File ref. no: BFS18/2791(4962)
Doc. ref. no: D18/80847
Contact: Qualified Firefighter Nathan Everett

**Notice of Exhibition
Prestons Industrial Estate (SSD 7155 MOD 6)
5-35 Yarrunga Street, Prestons (Liverpool LGA)**

I refer to the submission of the Notice of Exhibition (the Notice) dated 02 October 2018 for the above development to Fire + Rescue NSW (FRNSW) for review and comment. It is understood that the Notice is in regard to a modification application for Warehouse 5 of the subject development and includes expansion of the existing warehouse and construction of; ancillary office space, hardstand areas, car parking, and changes to vehicular access. An Environmental Assessment report (the Report) including a number of accompanying drawings and assessments have been prepared in support of the application.

Warehouse 5
BUILDING FLOOR PLAN
Drawn: AA
Date: AUGUST 2018
Scale: 1:500 @ A1
Project No: 140604
Drawing No: DA - A 251
Issue: H

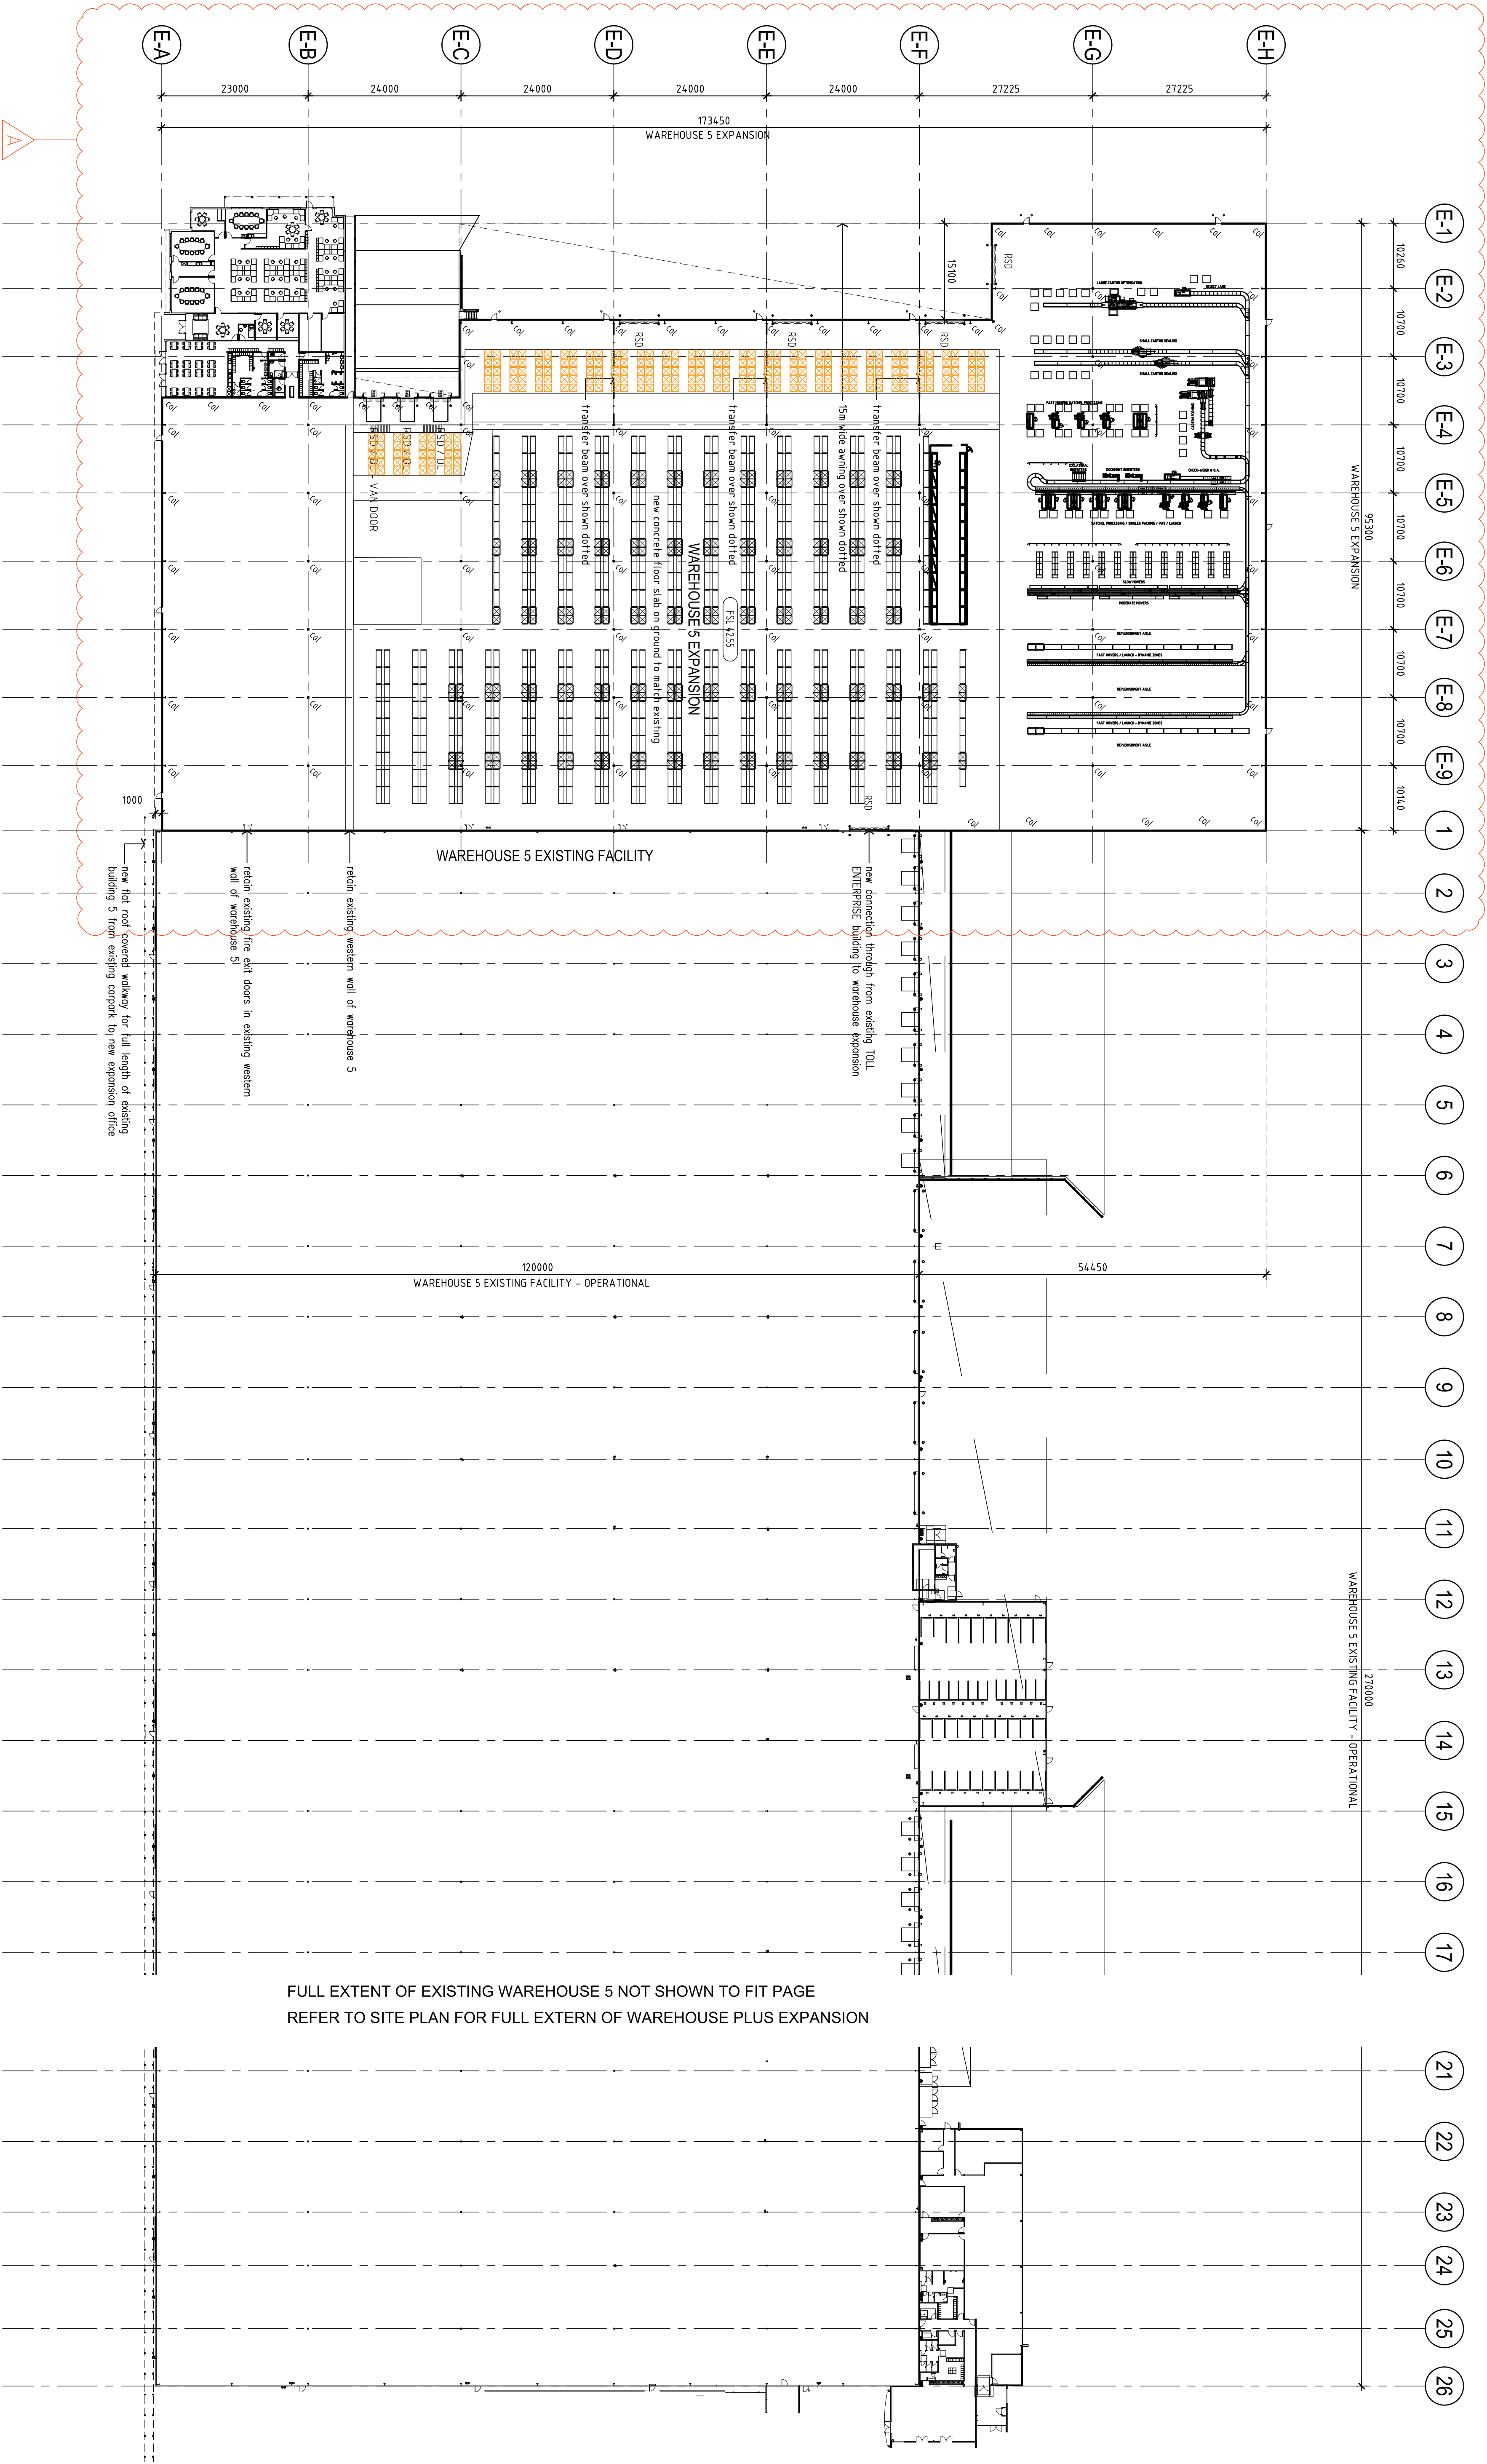
- It is noted that in Appendix J – *Hazard and Risk Assessment* of the original submission that SEPP 33 does not apply to the development and a Preliminary Hazards Analysis is not required.
- Appendix E – *BCA Assessment Report* of the original submission has identified that a number of alternative solutions will be required to address the performance requirements of the National Construction Code (NCC).
- The warehouse facility will be considered a 'Large Isolated Building' based on the building size and classification provisions within the NCC.
- It has not been identified if the existing warehouse is serviced by an automated high-bay racking system or if one will be installed within the extension.

- Consideration be given as to whether the nature or quantity of materials stored in the warehouse would be deemed a special hazard such that parts E1.10 and E2.3 of the NCC are applicable.

- Consultation with FRNSW be undertaken by way of the Fire Engineering Brief Questionnaire (FEBQ) process prior to the issue of the relevant construction certificate. This should be inclusive of the existing warehouse such that the fire safety systems of the entire facility can be considered as a whole.

- If an automated racking equipment is to be installed in the warehouse that details be included in the above FEBQ/Fire Engineering Report (FER).
- Consideration be given to provision of adequate hydrant and hose reel coverage to all areas of the warehouse with details provided in the FEBQ/FER. Should it be deemed necessary to install additional hydrants internally within the warehouse, FRNSW will need to be consulted as to the proposed locations before support is provided.
